REFUSAL OF PLANNING PERMISSION

APPLICATION NO. 2018/0812

Proposal Erection of 1no. detached bungalow

At Land adjacent 103A Ingsfield Lane, Bolton Upon Dearne, Rotherham, S63 8EB

Project	New Build Bungalow in Barnsley		
Address	103a Ingsfield Lane, Rotherham S63 8EB		
Title	Proposed Elevation		
Dwg No.	02	Date	JUNE 2018
		Scale	1/75 @ A3
		REV	B

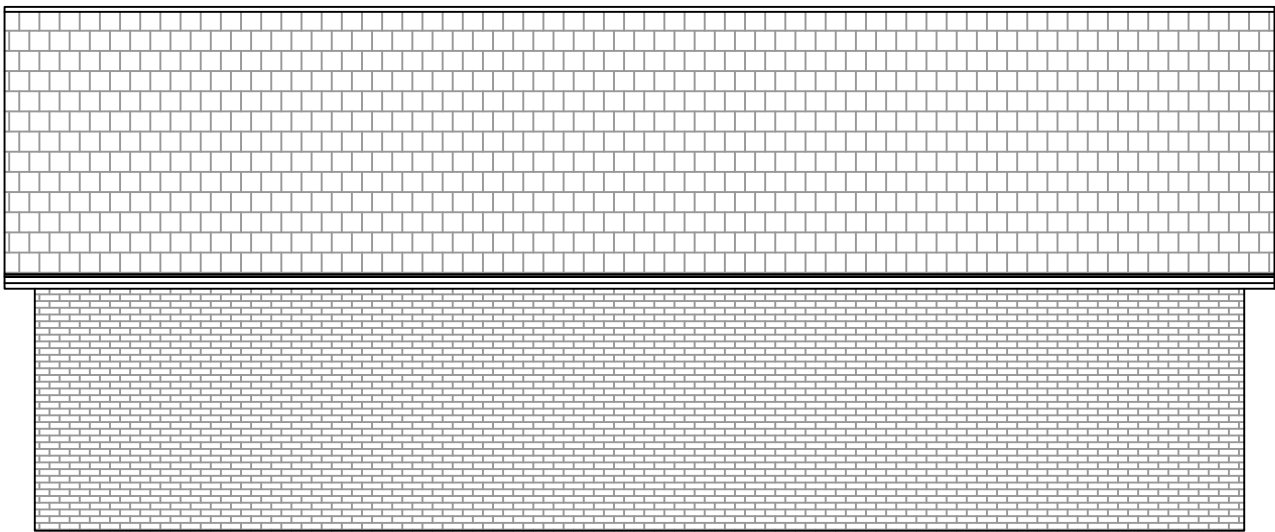
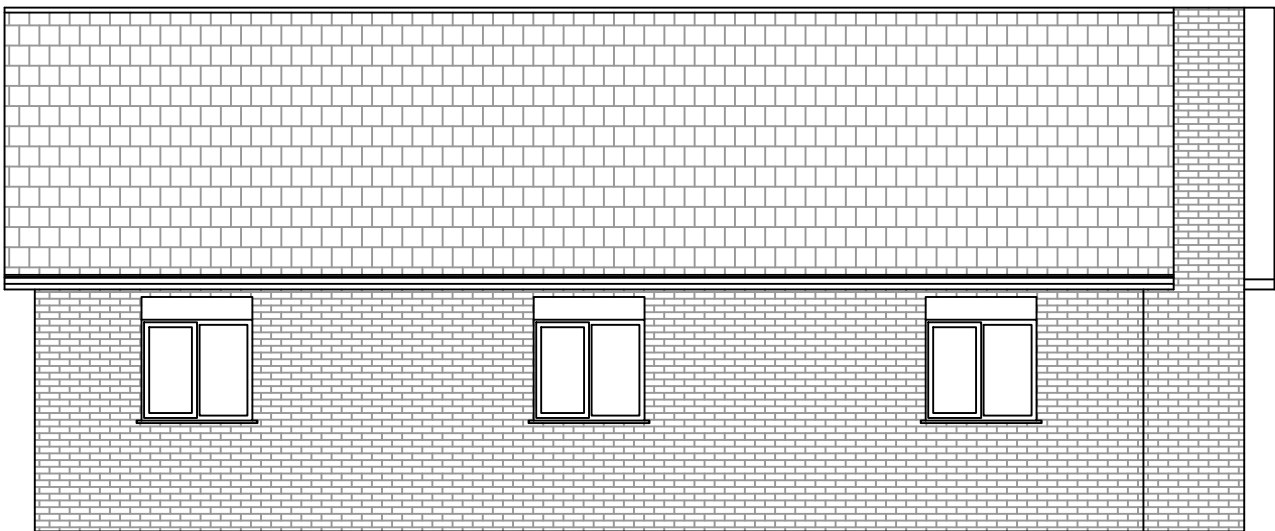
- 1 This proposal represents an incongruous form of the single storey development that fails to take the opportunities available for improving the character and quality of the area, and would be out of character with the established pattern of two storey terraced development on this side of Ingsfield Lane. This would be contrary to Core Strategy policy CSP29 Design and Paragraph 130 of the NPPF.
- 2 The proposal represents an over development of the site (as demonstrated by amongst other things inadequate sized parking spaces, small garden areas, over hanging eaves on both sides and side facing habitable room windows) that would appear out of character with the street scene to detriment of the character and appearance of Ingsfield Lane and contrary to Core Strategy policy CSP29 Design.
